CITY OF ALBUQUERQUE

January 17, 2017

**RE: U-Haul at West Bluff
Atrisco Drive NW
Grading Plan and Drainage Report
Engineer's Stamp Date 12-5-2016 (File: H11D059)**

NORTH ENTRANCE
SC: 1"=10'

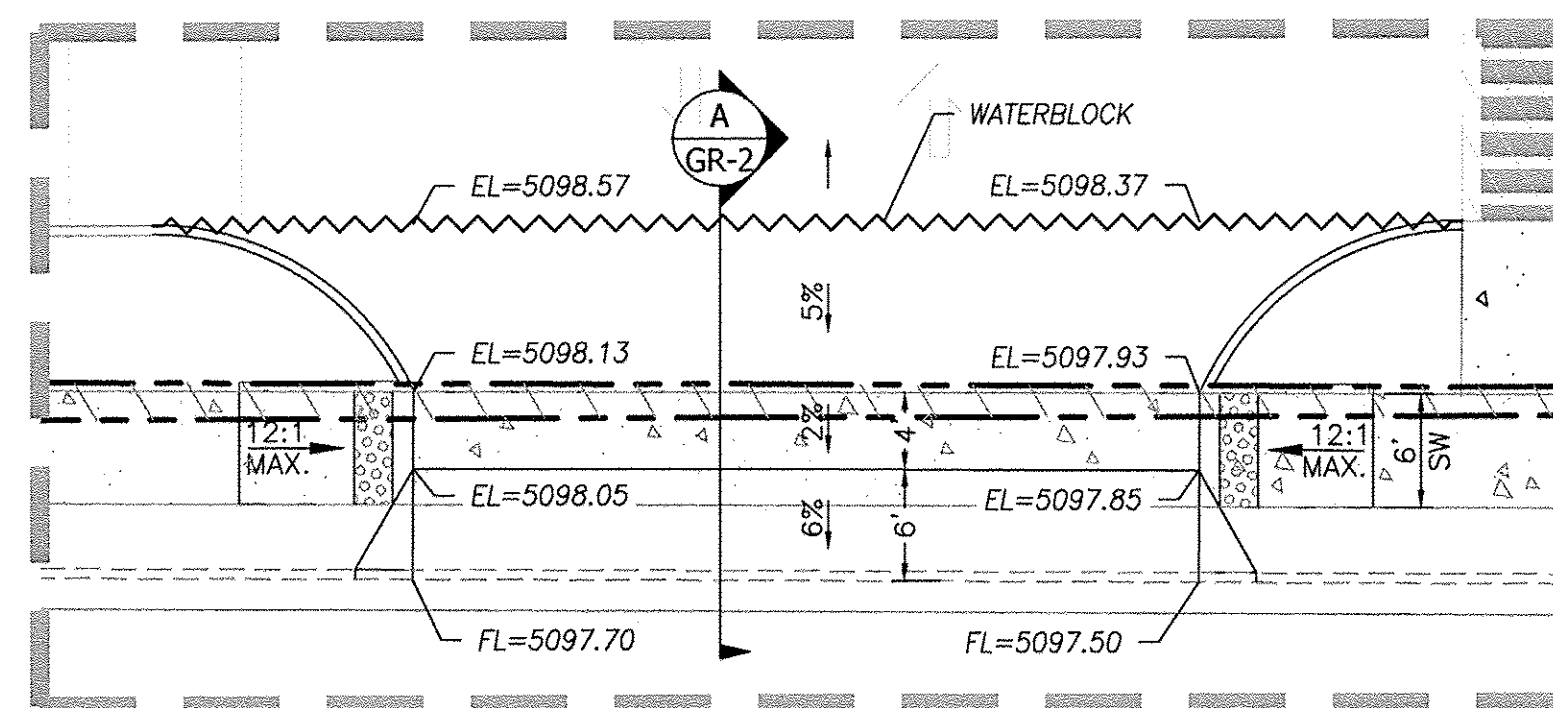
1. The North detention pond appears to be bounded by a CMU retaining wall as high as 8 feet in some places. This will need to be enclosed with a fence at least 42 inches high.

2. Call out Class IV RCP for the north detention pond outfall pipe under the retaining wall.
3. Additional detail is required for the two curb cuts and their associated water blocks to ensure ADA compliance for pedestrian traffic along Atrisco. Provide section views at these locations, including flow line elevation, slope, and waterblock elevations.

4. Project Benchmark and Vertical Datum is missing from the sheets. The Drainage Management Plan addresses the NGVD29 to NAVD88 shift, but sheets need this information as well.

5. A portion of the sidewalk is within the parcel property, if there is no existing sidewalk easement, one will need to be provided.
6. Verify that the two drop inlets are capable of handling twice the 100-yr flow at the sump on Atrisco. It appears this location has a single-C and double-C on each side of the road. If these inlets are insufficient, additional inlets will be needed on the new lateral from the north pond to prevent flows from spilling over into the north pond.
